From: Jeff Rice
Sent: Tuesday, September 17, 2019 8:40 PM
To: Jeff Hodsdon; John P. Schwab
Cc: Matt Dunston; Bill Dunston; Sword - CDOT, Valerie; 'Gonzales - CDOT, Arthur'; Duncan Bremer; Nina Ruiz; Craig Dossey; Jennifer Irvine; Elizabeth Nijkamp; Lori Seago
Subject: Monument Academy - Traffic/Access

County Staff has reviewed the most recent TIS for the project and has coordinated with CDOT staff regarding design requirements this afternoon. Regardless of CDOT access permit requirements (conditions), we wanted to provide the following County requirements in advance of the complete, detailed comments:

C1.1

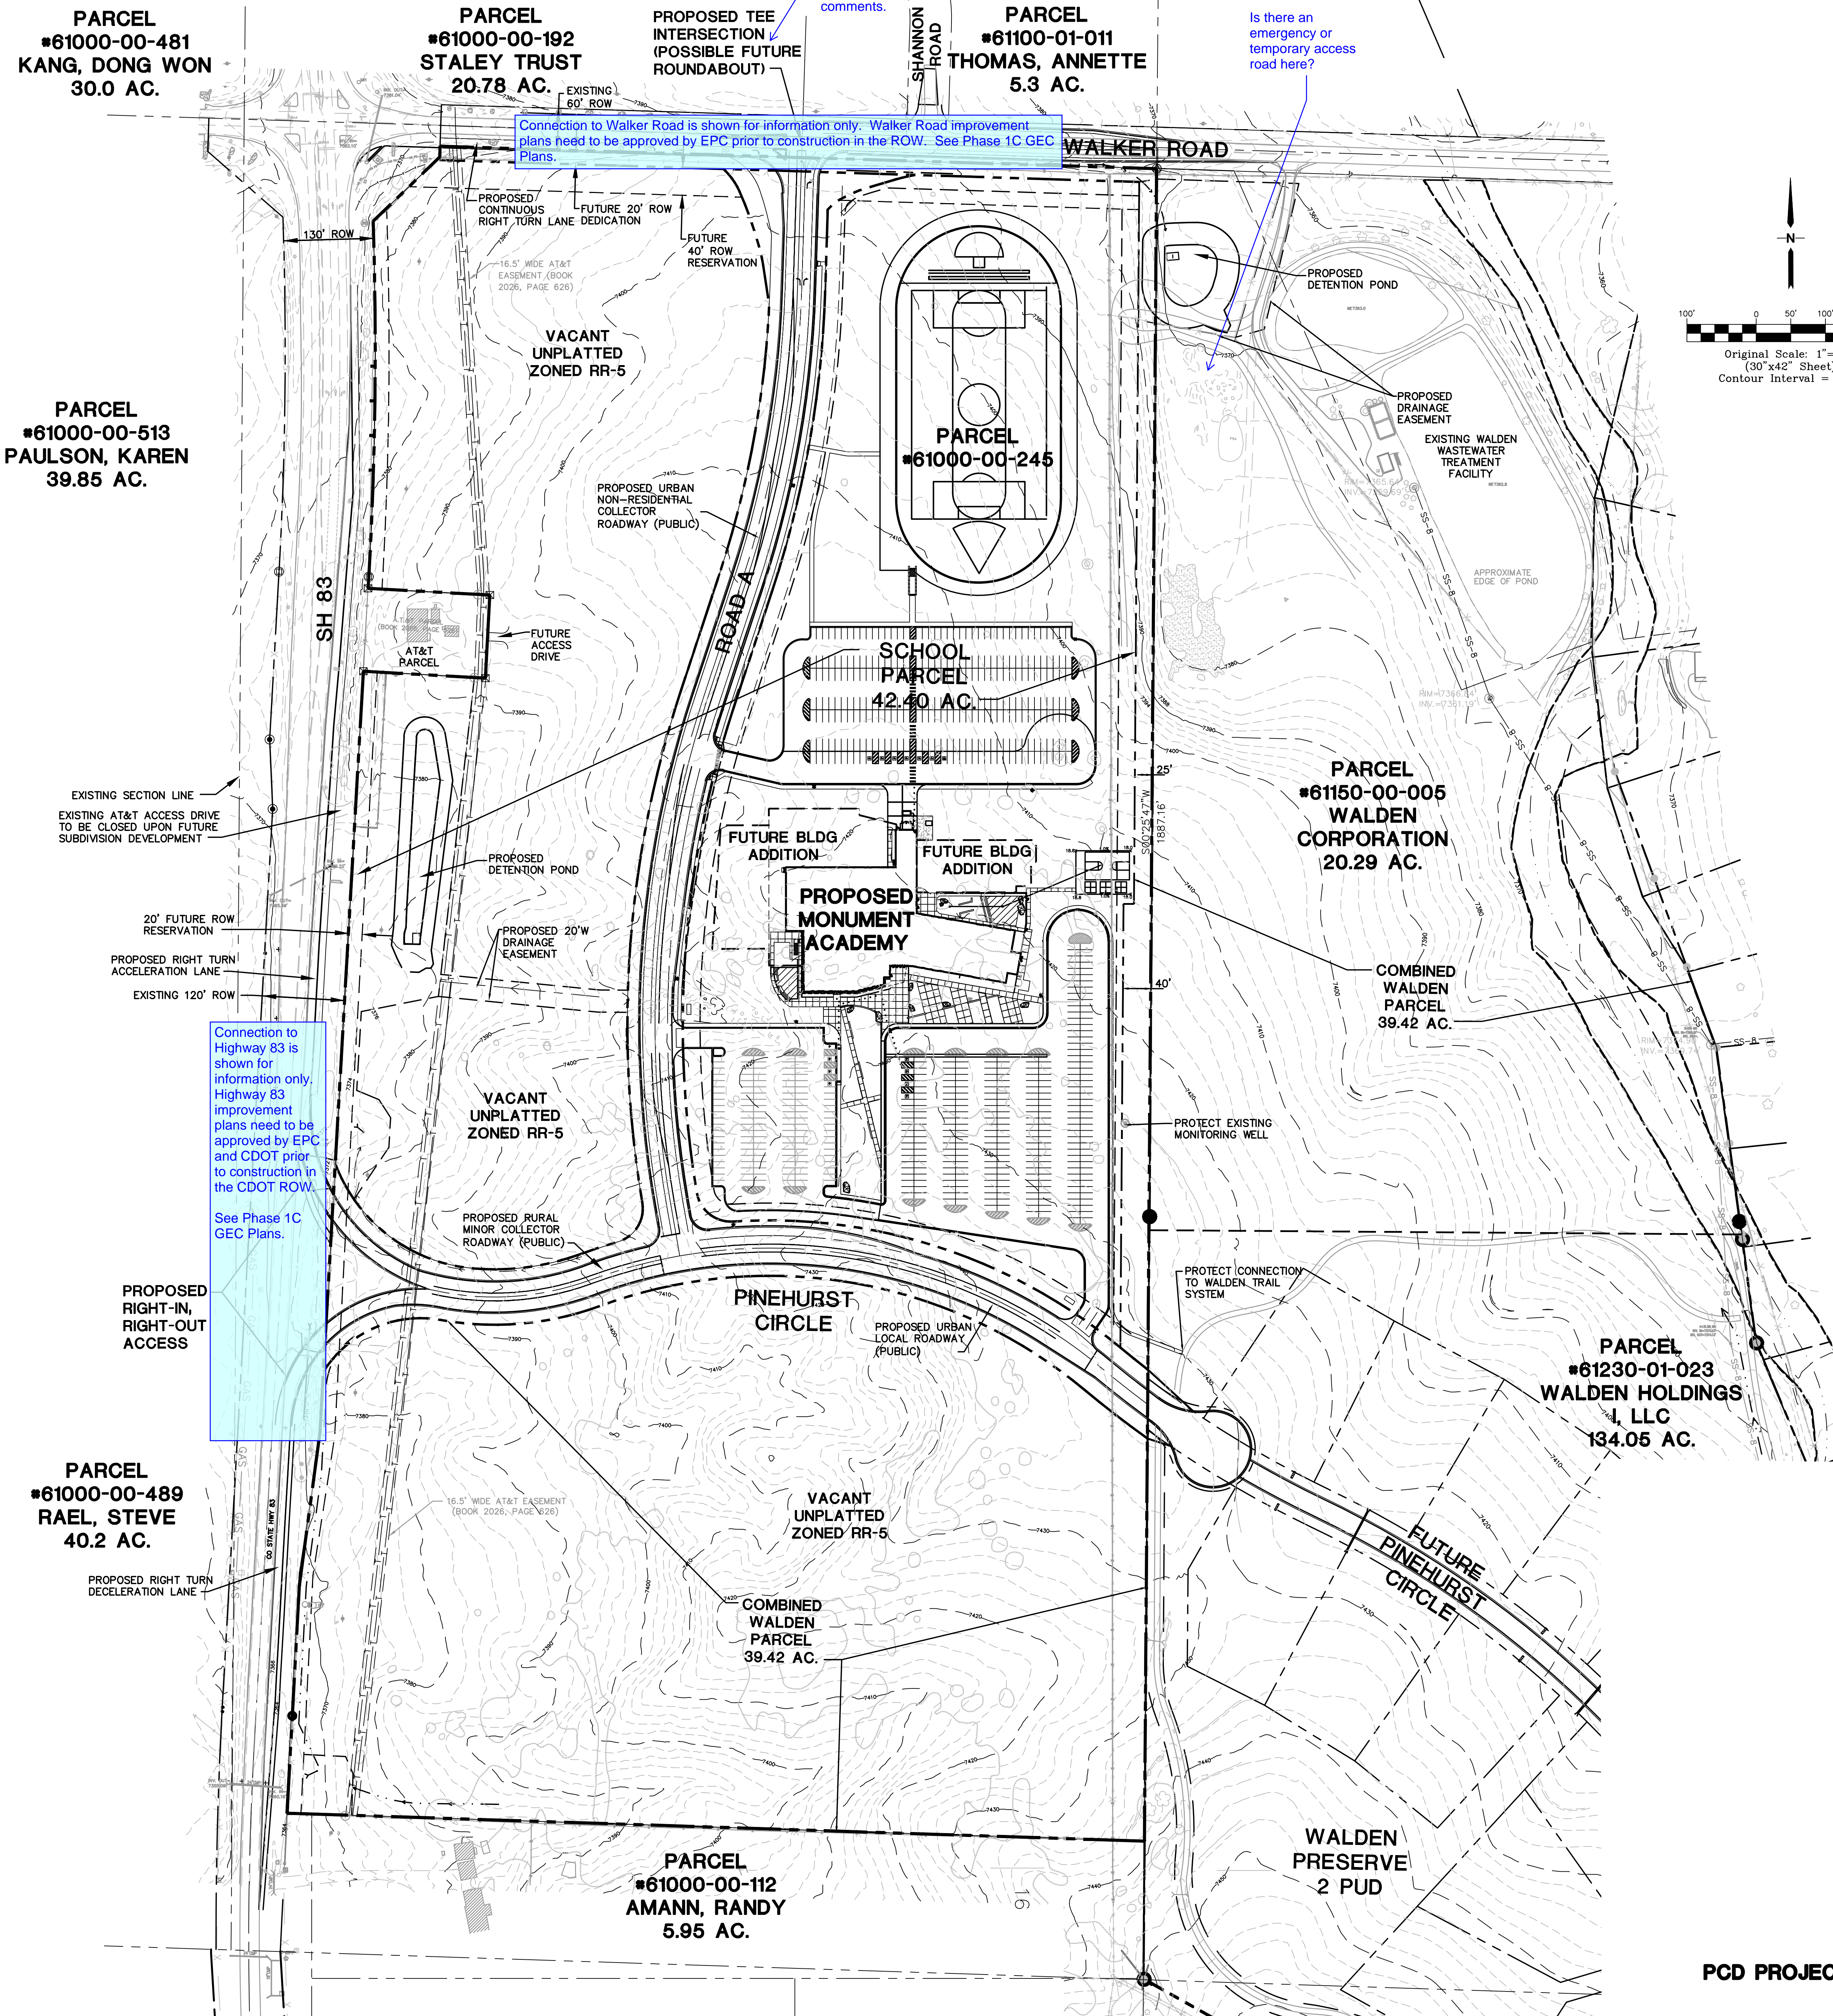
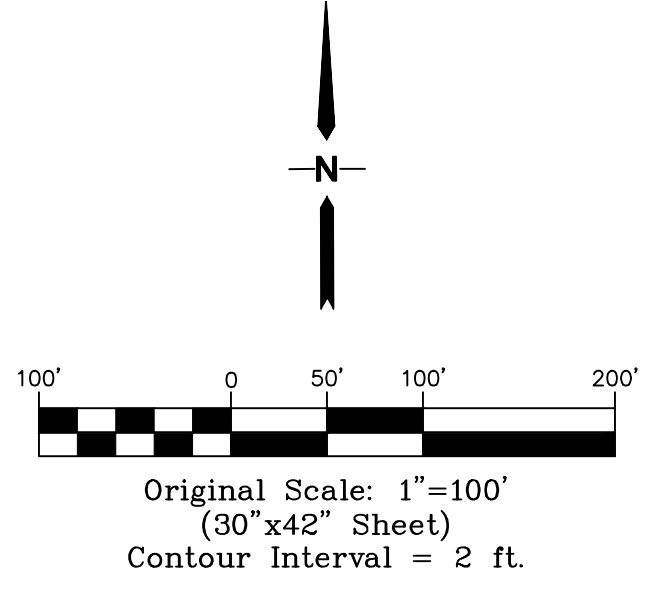
1. Based on the options presented in the TIS, the intersection of Walker Road and proposed Road A (Jane Lundeen Drive) shall be constructed as a one-lane roundabout which allows for expansion to two lanes in the future. This needs to be done prior to the school opening. The use of a traffic signal or three-way stop does not appear to be warranted nor appropriate for the anticipated traffic patterns, and reconstruction of the intersection for Phase 2 of the development after the school has opened will not be feasible. If right-of-way from the property owner to the north is not available the roundabout shall be shifted to the south as necessary.

2. As part of the roundabout design, the sight distance issue along Walker Road needs to be addressed. It is anticipated that grading will be required to lower the elevation of the hill crest to provide acceptable sight distances and vertical curves approaching the roundabout.

4. Due to the proposed traffic volumes, the road cross-sections through the site shall be curb and gutter except for the east end of Pinehurst Circle east of the southeast parking lot access which will transition to the rural cross-section.

5. Sidewalks adjacent to Pinehurst Circle and Jane Lundeen Drive shall be completely constructed along the west and south sides of the school parcel (along the developed property). All curb and gutter roads will require sidewalk adjacent to developed areas. This will also be addressed in the development agreement.
